Environmental Health Division
1675 W. Garden of the Gods Road
Suite 2044
Colorado Springs, CO 80907
(719) 578-3199 *phone*
(719) 578-3188 *fax*
www.elpasocountyhealth.org

Loudermilk Subdivision, MS-19-002

Please accept the following comments from El Paso County Public Health regarding the project referenced above:

GENERAL GEOLOGY AND ENGINEERING GEOLOGY MAP

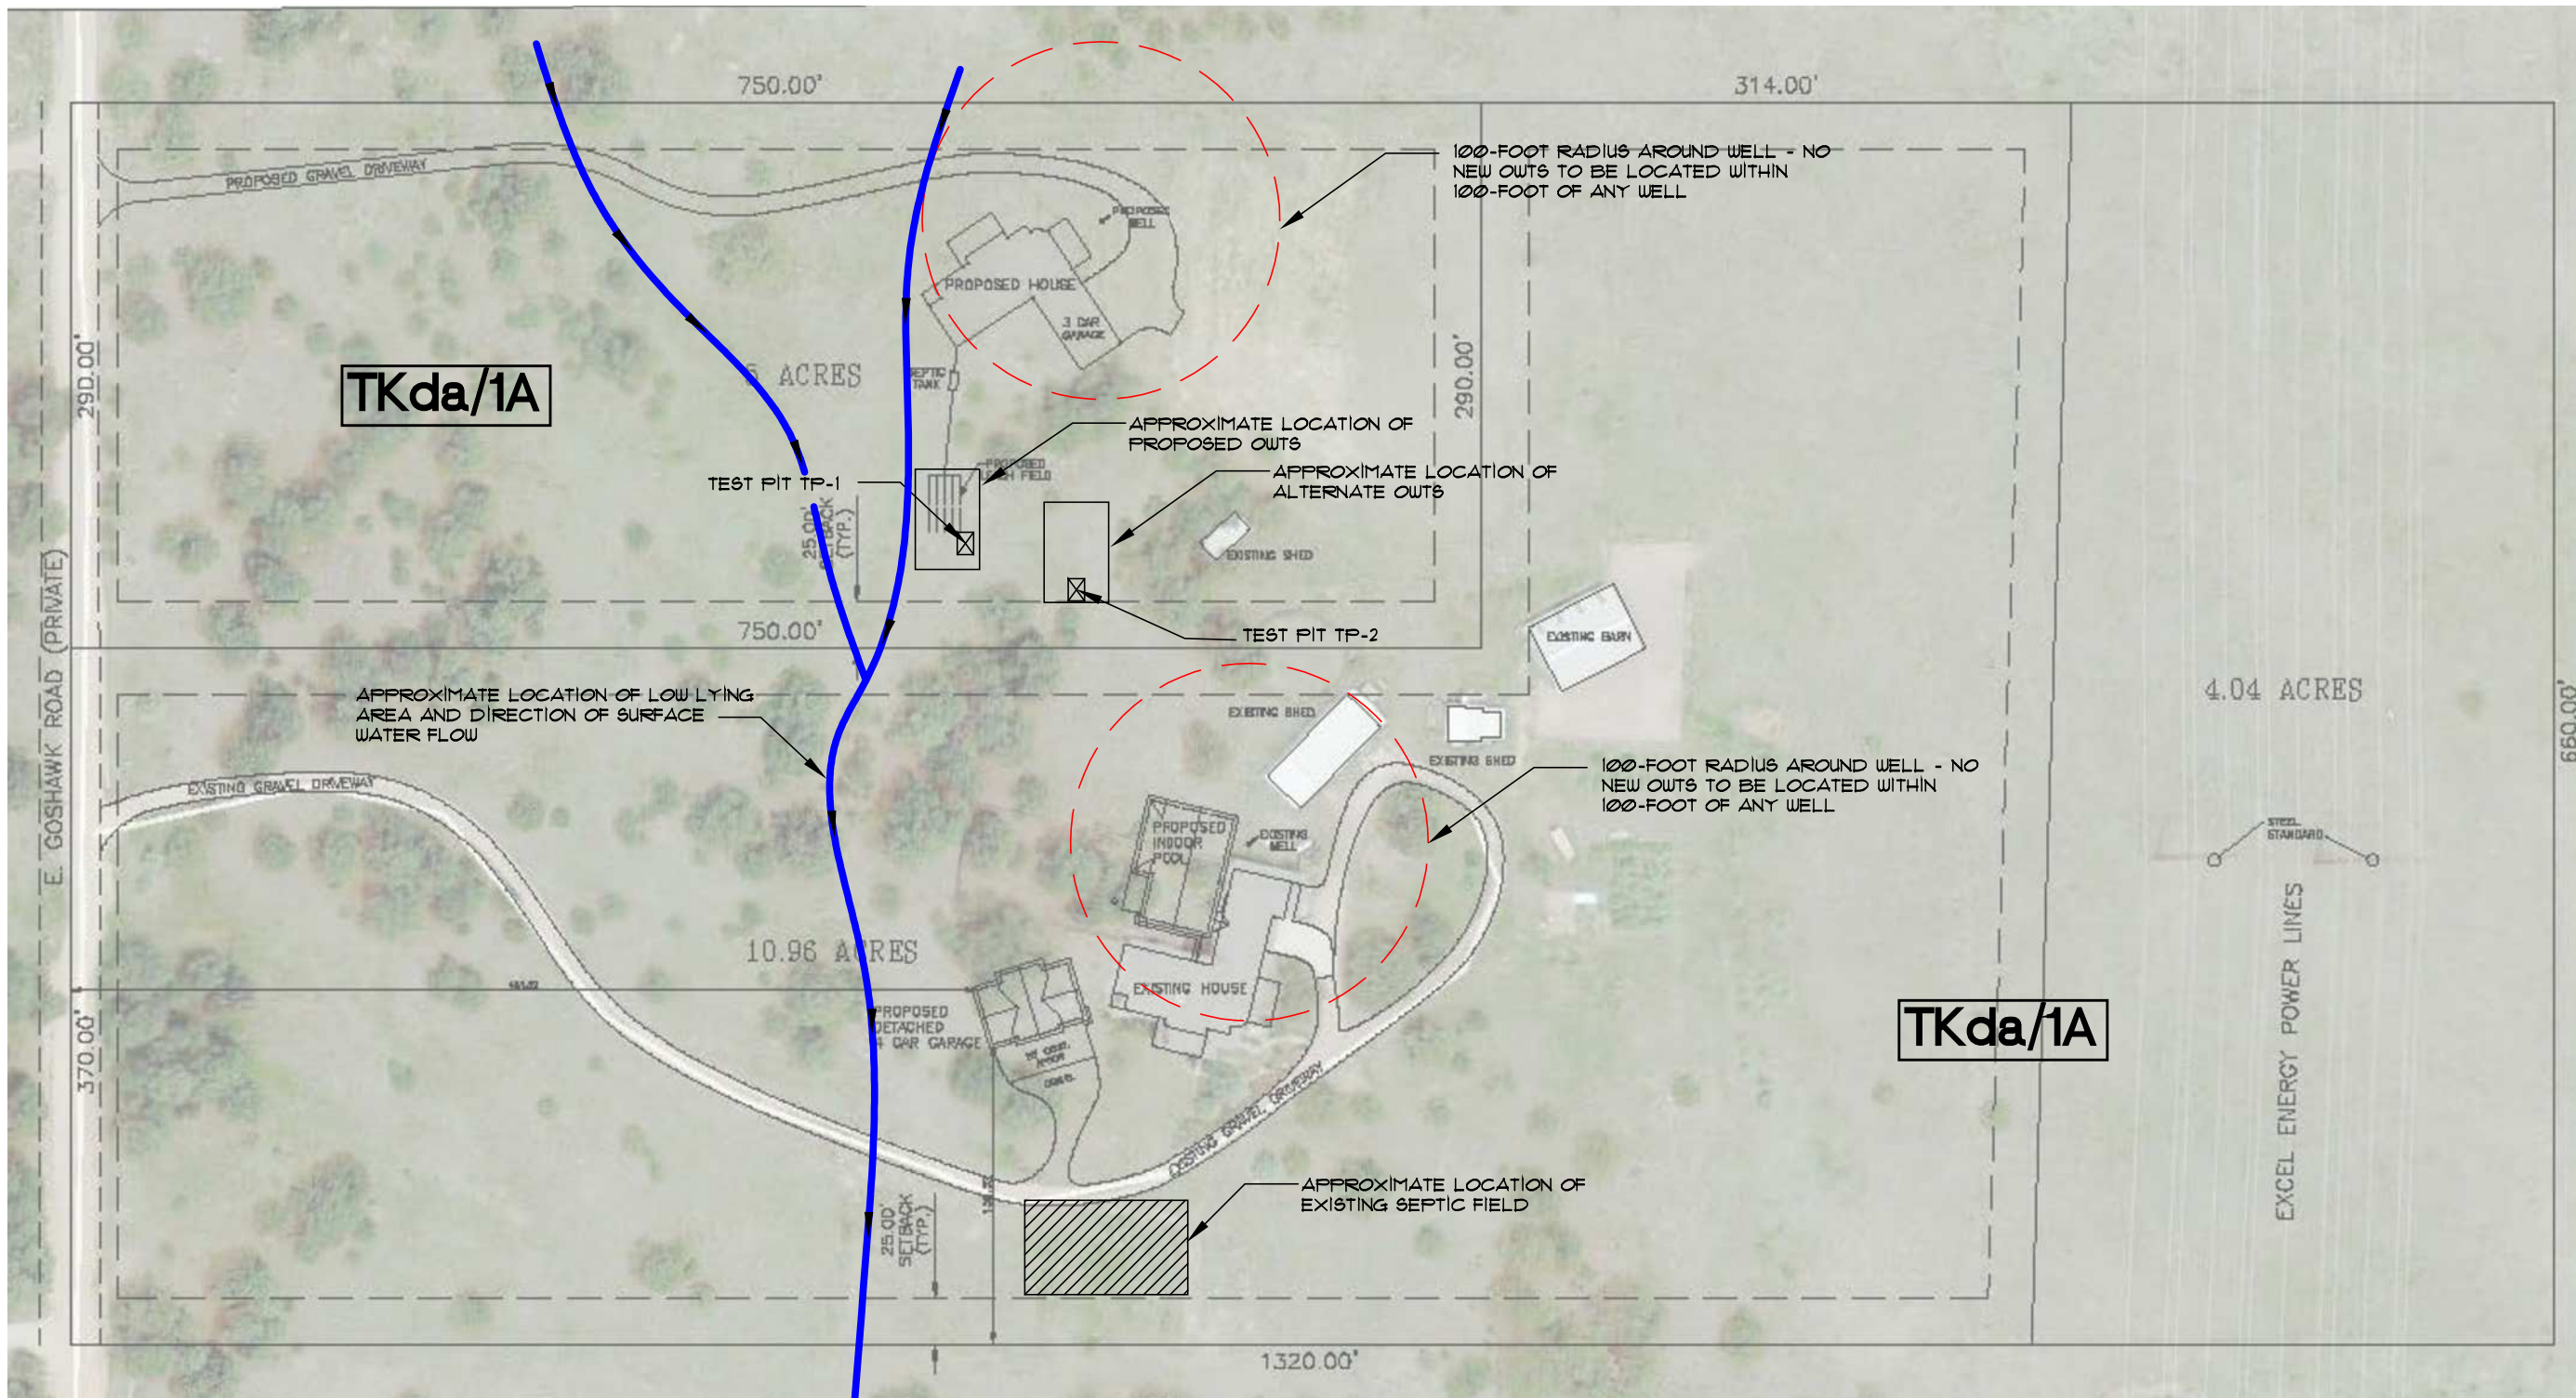
- **Adjacent property well locations were not shown; therefore, be aware of the specific 100'+ setback requirements to exterior wells.**
 - **The existing soil treatment area of the developed lot is in close proximity to the proposed new 4-car garage. This area must be protected from compaction by vehicles and construction equipment. A fence or barrier around this area is encouraged to be installed during construction.**
